Subject: B7 Design Review – 195 Kennebec Street Revisions

Written by: Caitlin Cameron, Urban Designer

Date of Review: Friday, April 3, 2015

A2.01

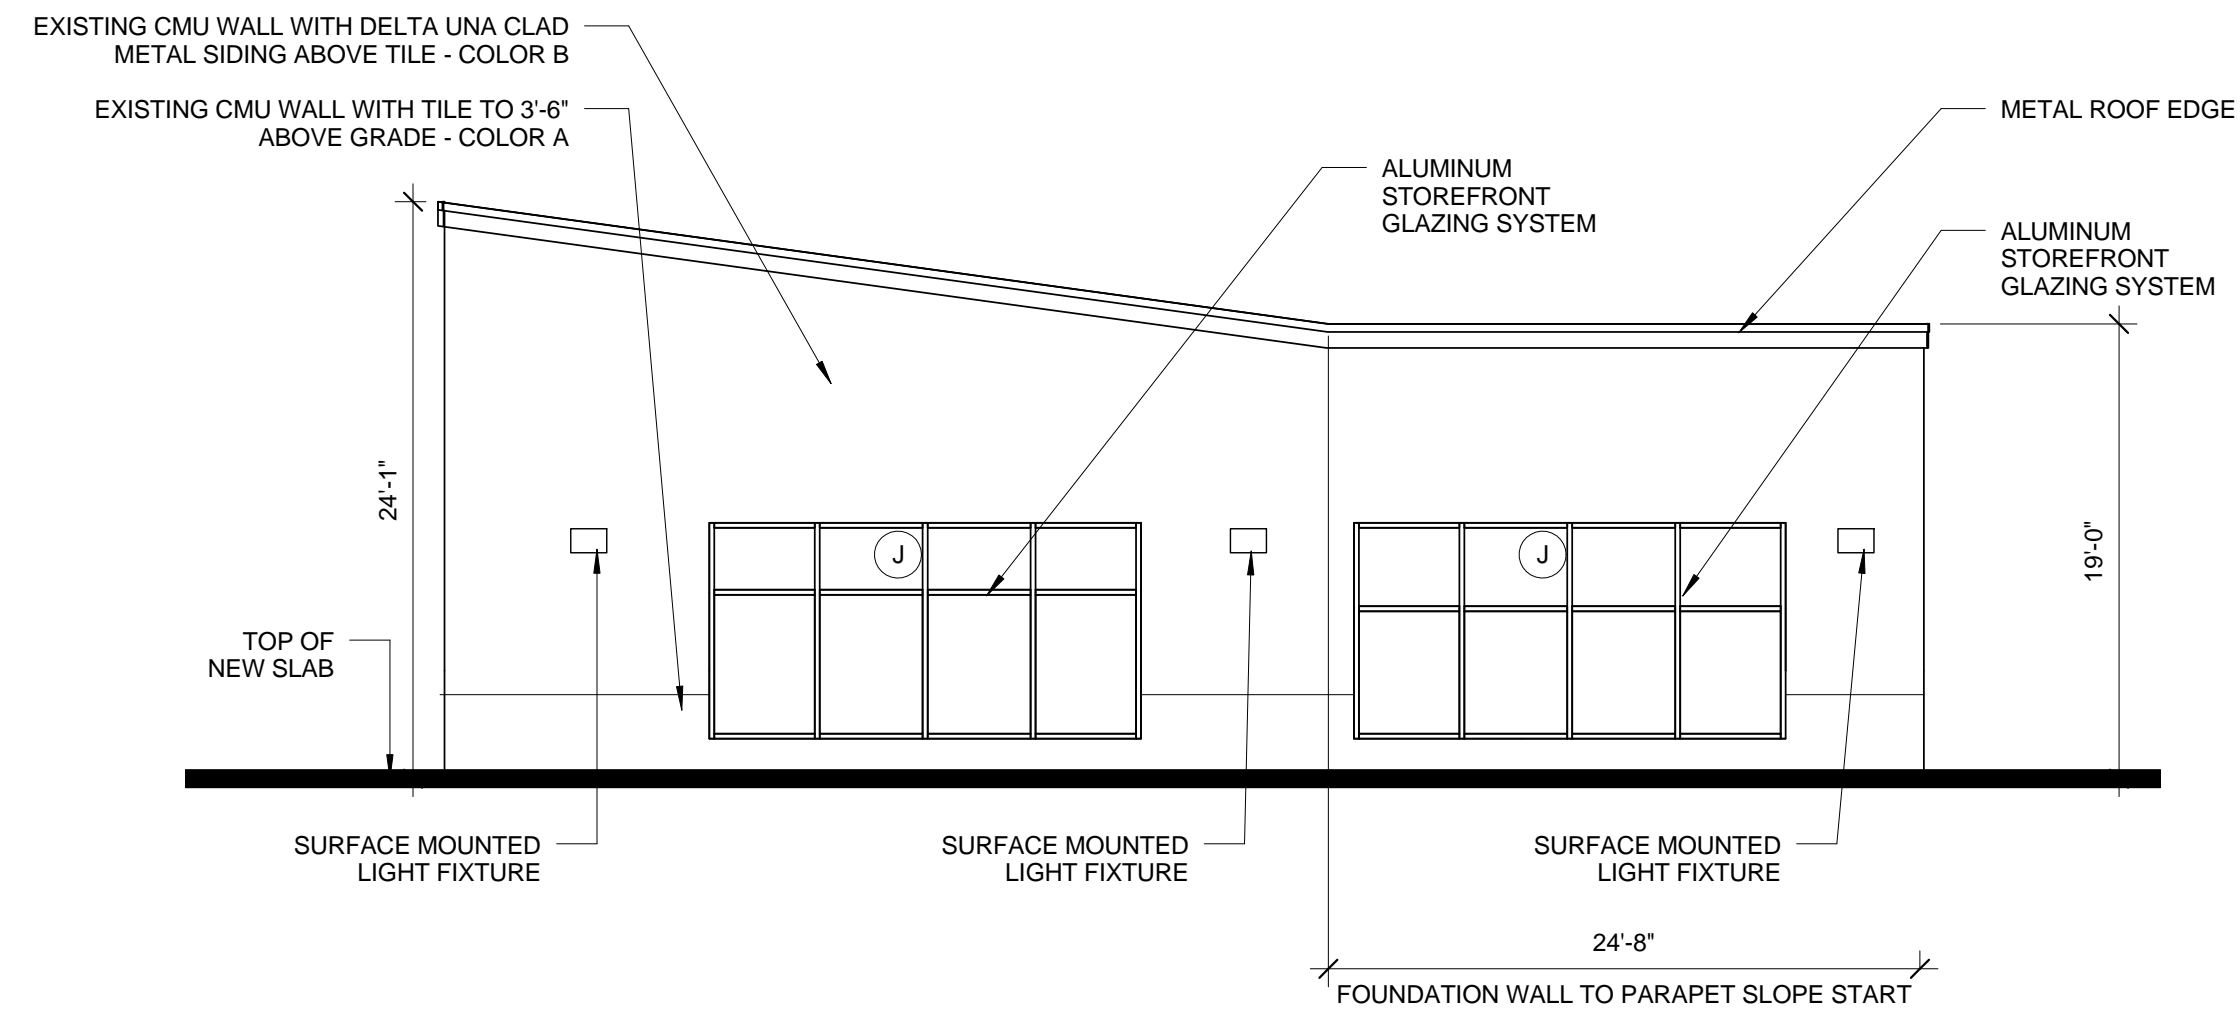
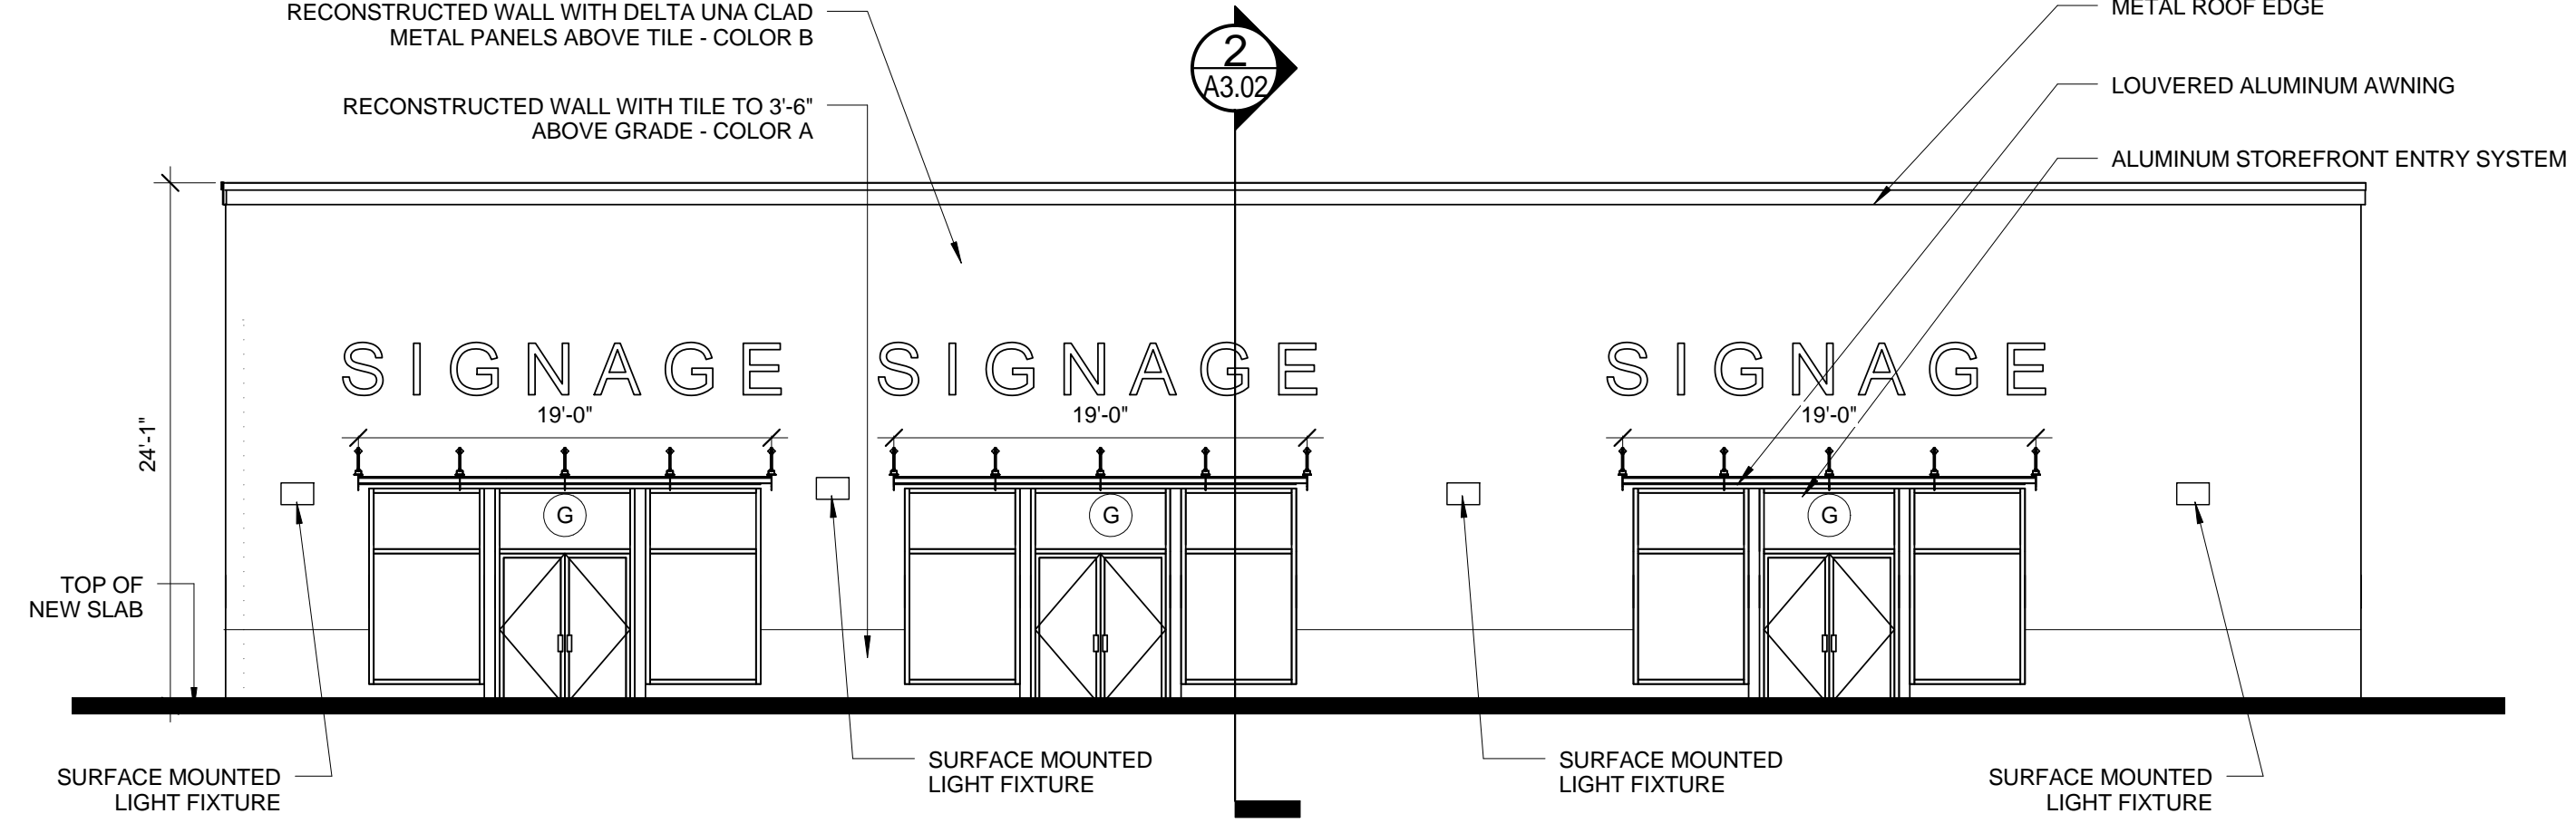
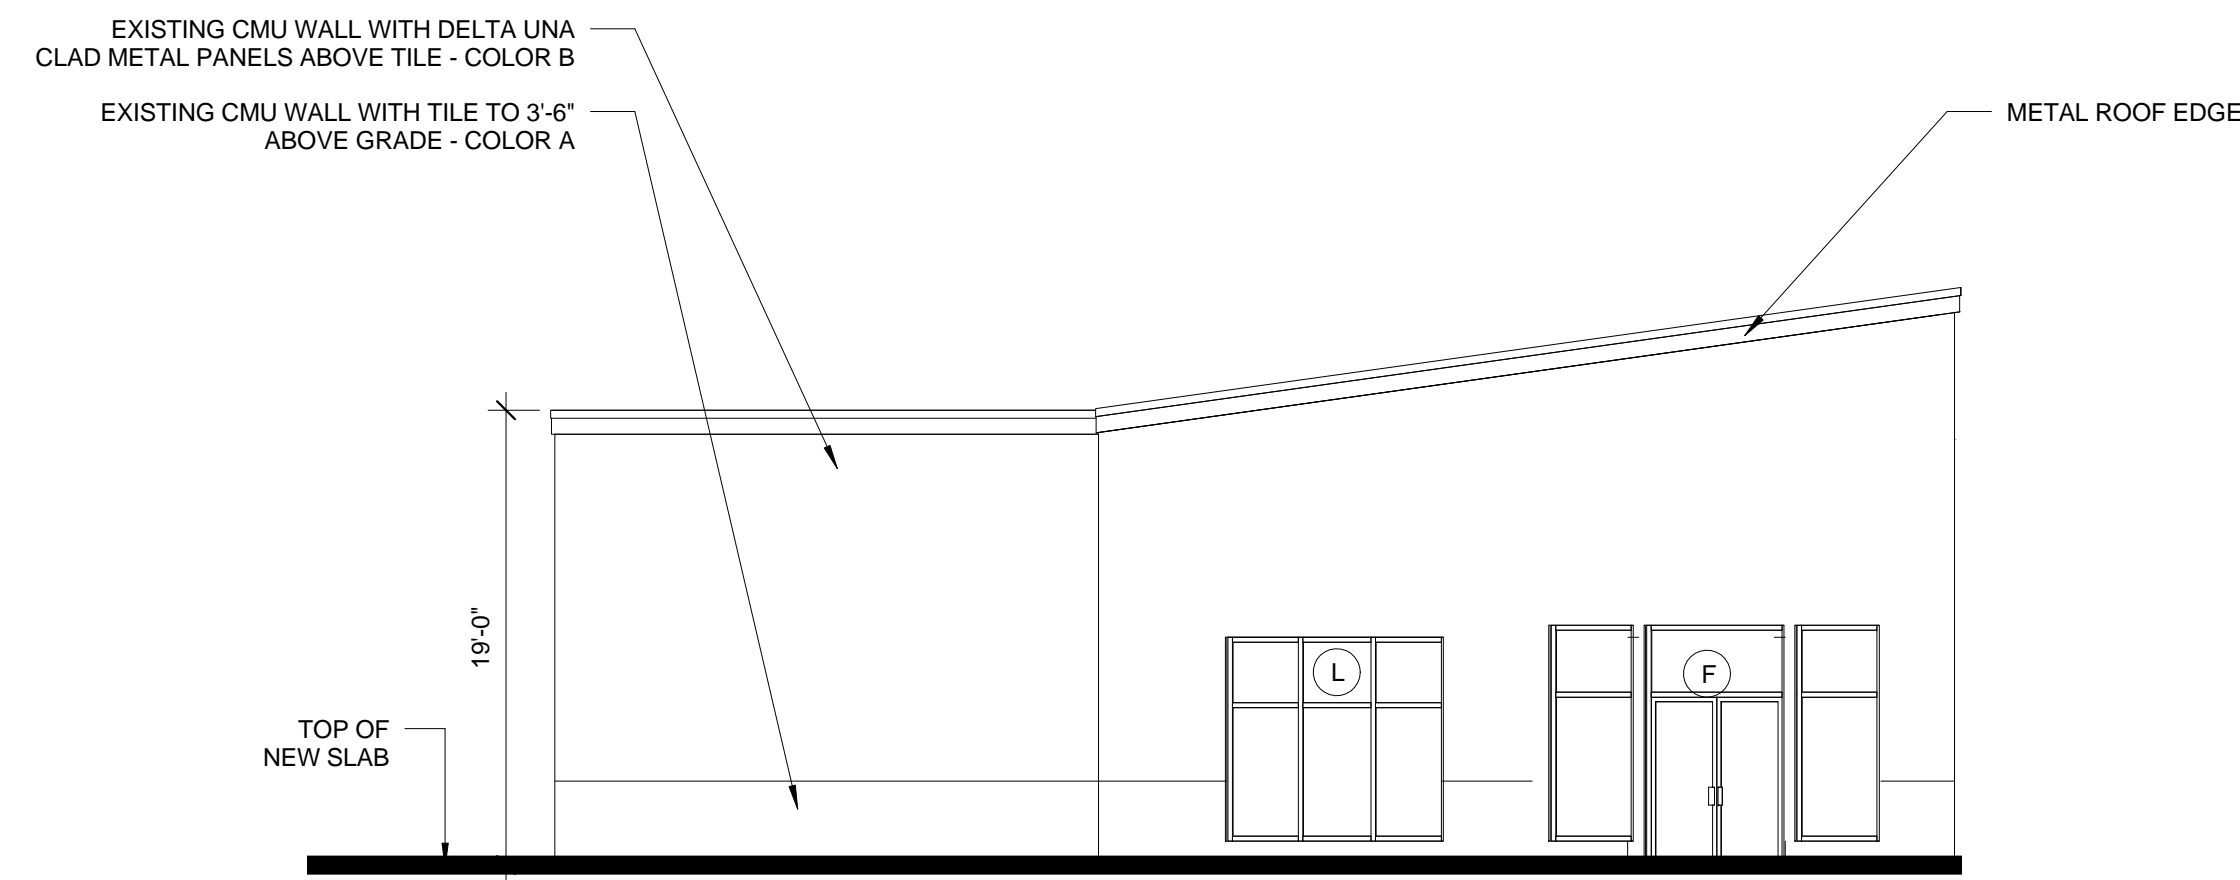
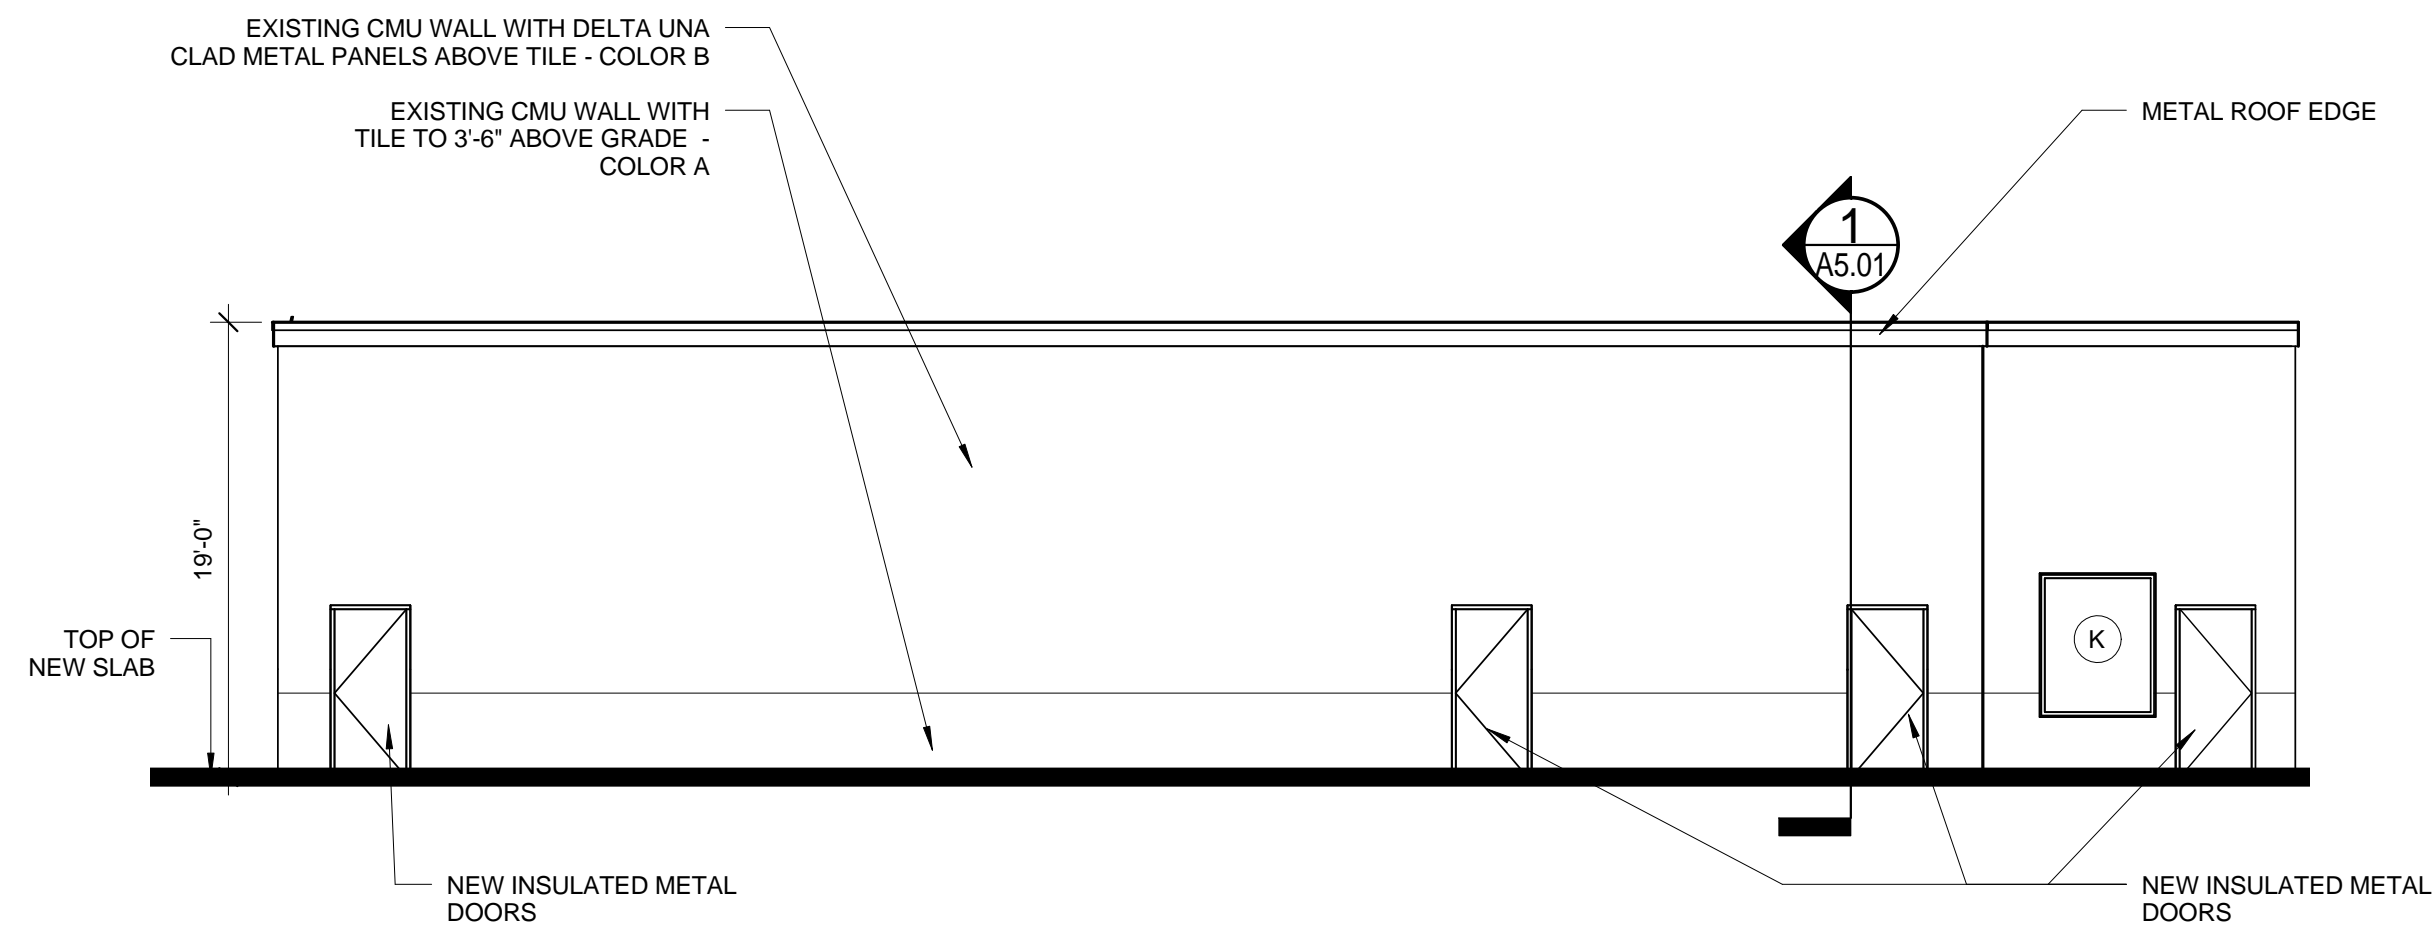
- **Building A** – The street-facing façade and entry should be given equal treatment to the other building entrances. In this case, that includes a sign, light, and canopy.

- **Building A** – The street-facing façade and entry should be given equal treatment to the other building entrances. In this case, that includes a sign, light, and canopy.
